Consultation Response from KC, Policy
2022/92471
Redevelopment of Heckmondwike Bus Station including a new concourse building with waiting room, Changing Places WC, driver offices, 6 No. bus stands, landscaping, and associated works
Date Responded: 29/09/2022

Responding Officer: Jacob Parker-Henry

1 Planning Site Plan
1 : 200

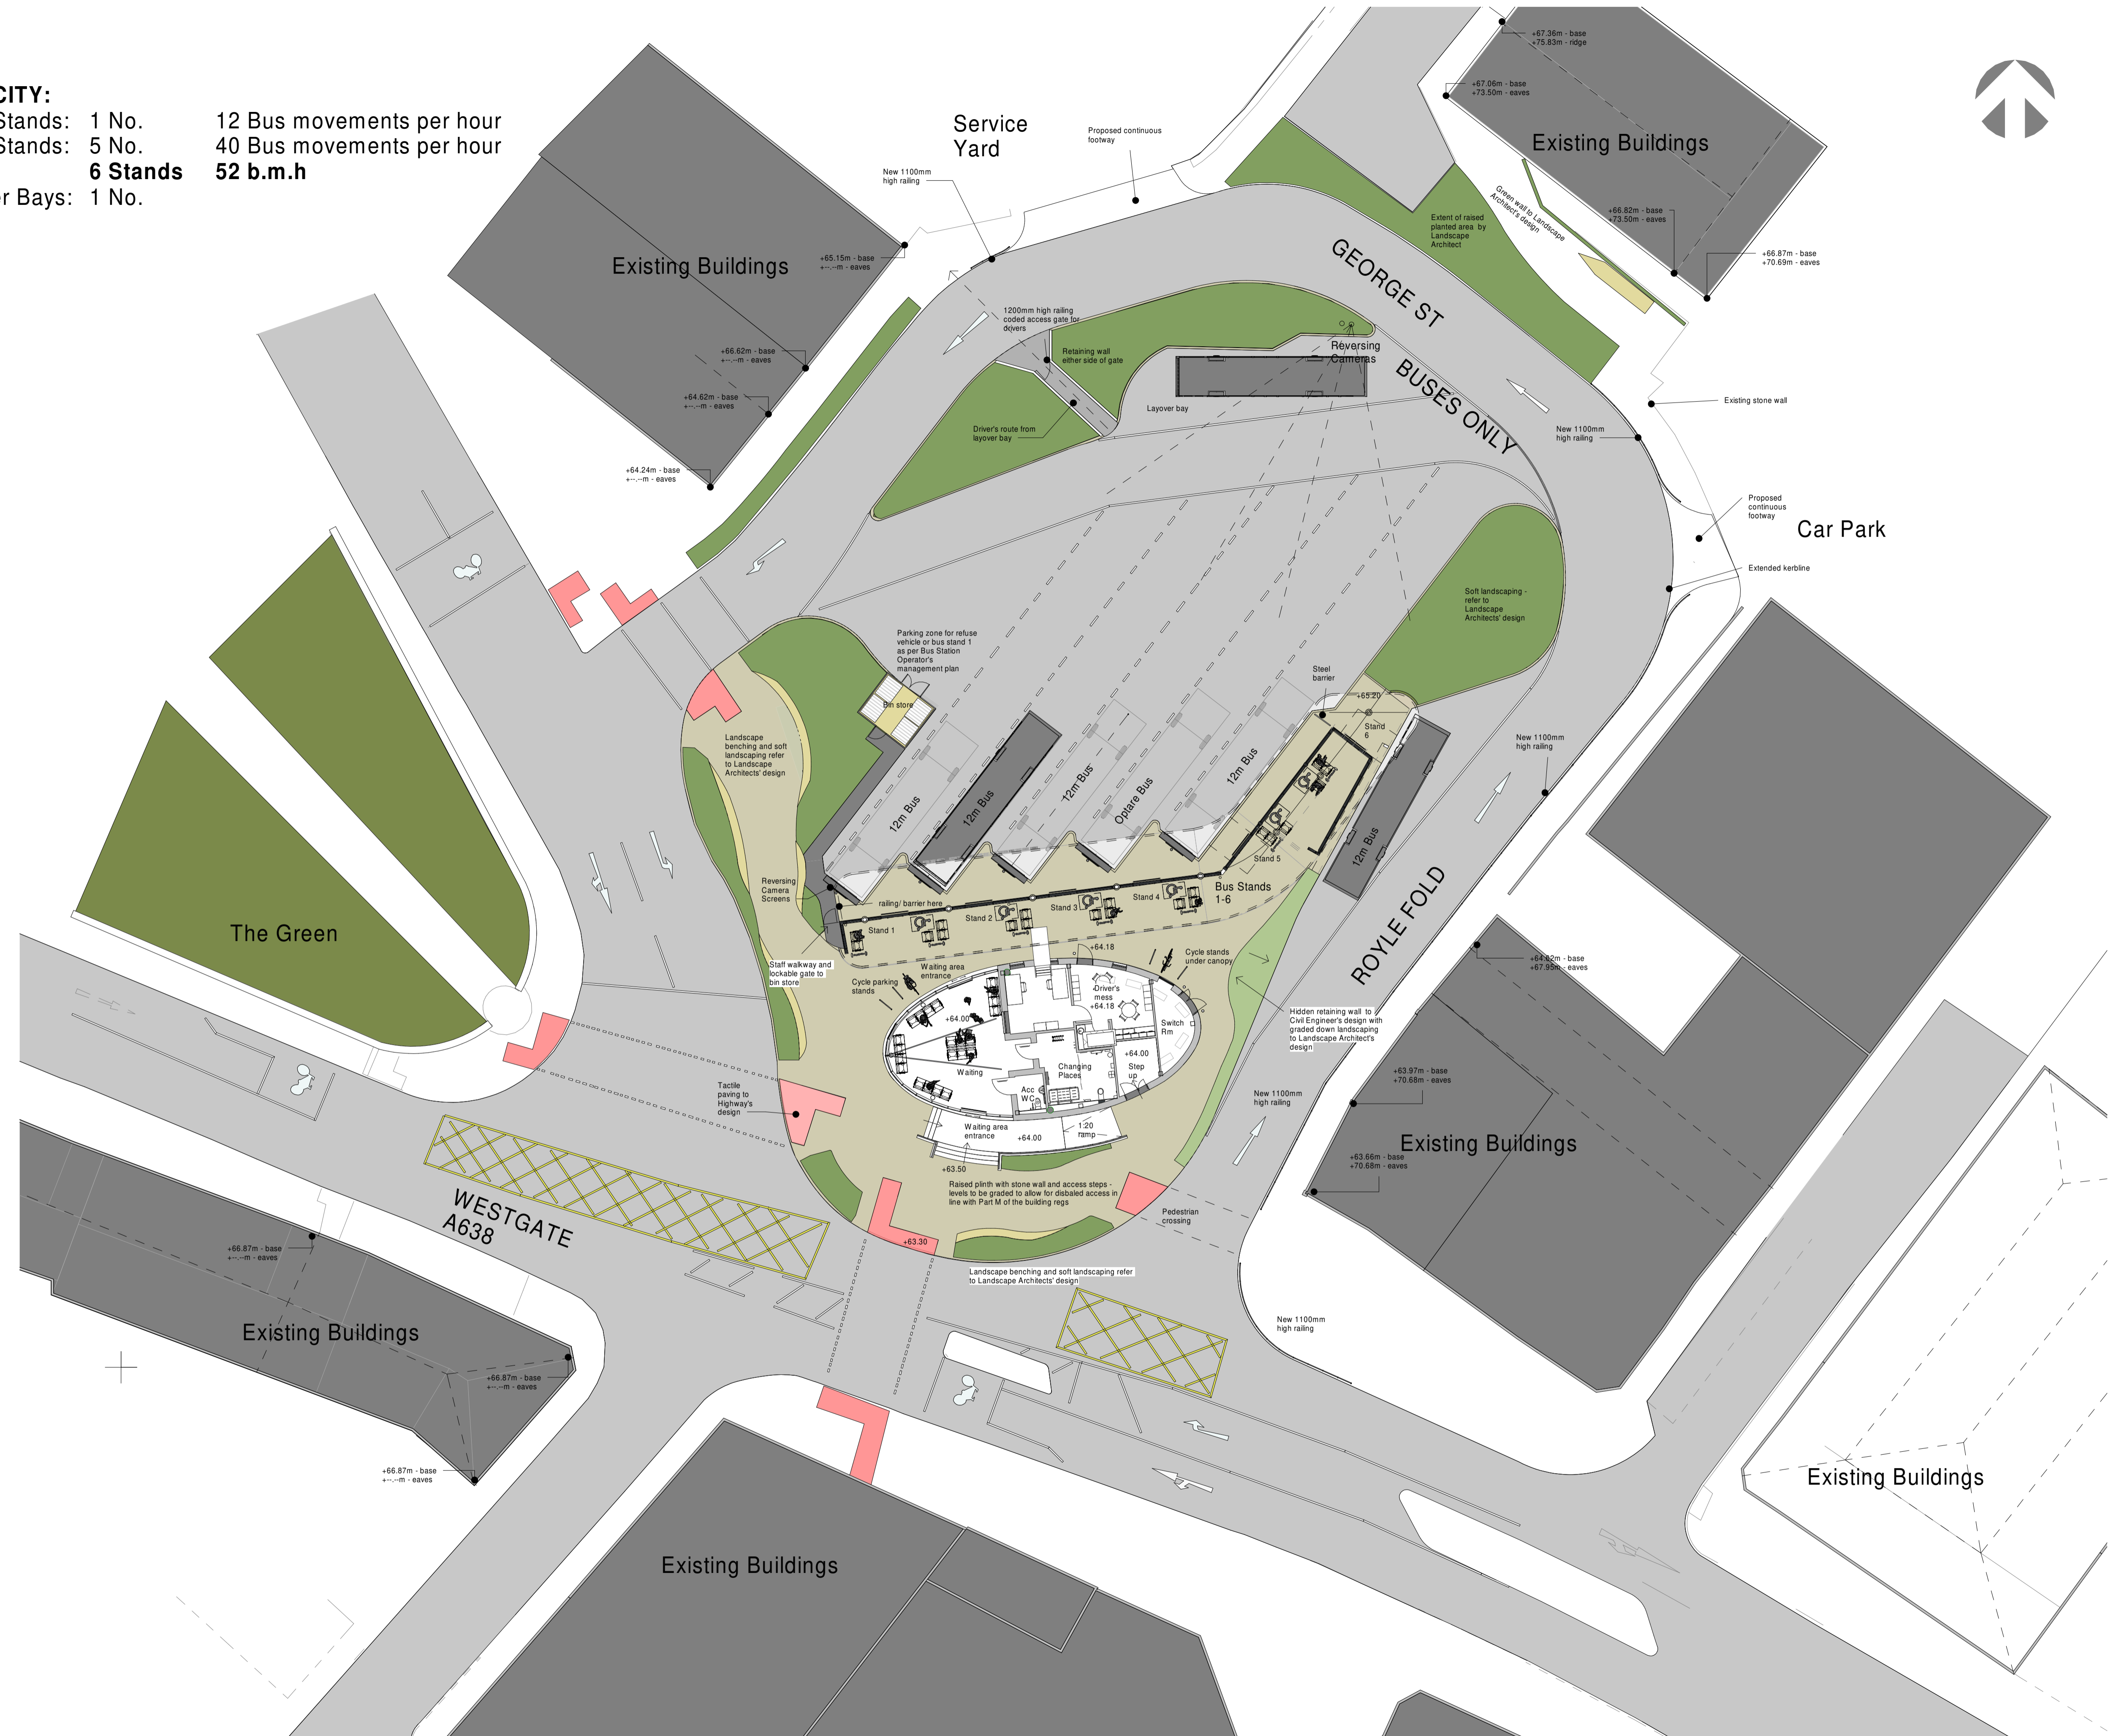
Therefore, due to the fact pedestrians and cyclists lie higher on the hierarchy, consideration needs to be given to the incorporation of pedestrians and cyclists in the design.

The current bus station has 4 parking spaces for cars, with 2 of these spaces being designated for disabled people. The proposed development removes all 4 of these parking spaces.

Furthermore, criteria (h) states *"provision will be made to accommodate the needs of disabled people for the parking of vehicles"*. Therefore, the applicant needs to demonstrate that the removal of the 2 disabled parking spaces does not negatively affect disabled people's access to the bus station.

To conclude, while this proposal is for sustainable transport, the design of the bus station still needs to consider other forms of sustainable transport such as walking and cycling., linking into existing and proposed networks, as well as accessibility for disabled people through design as well as parking.
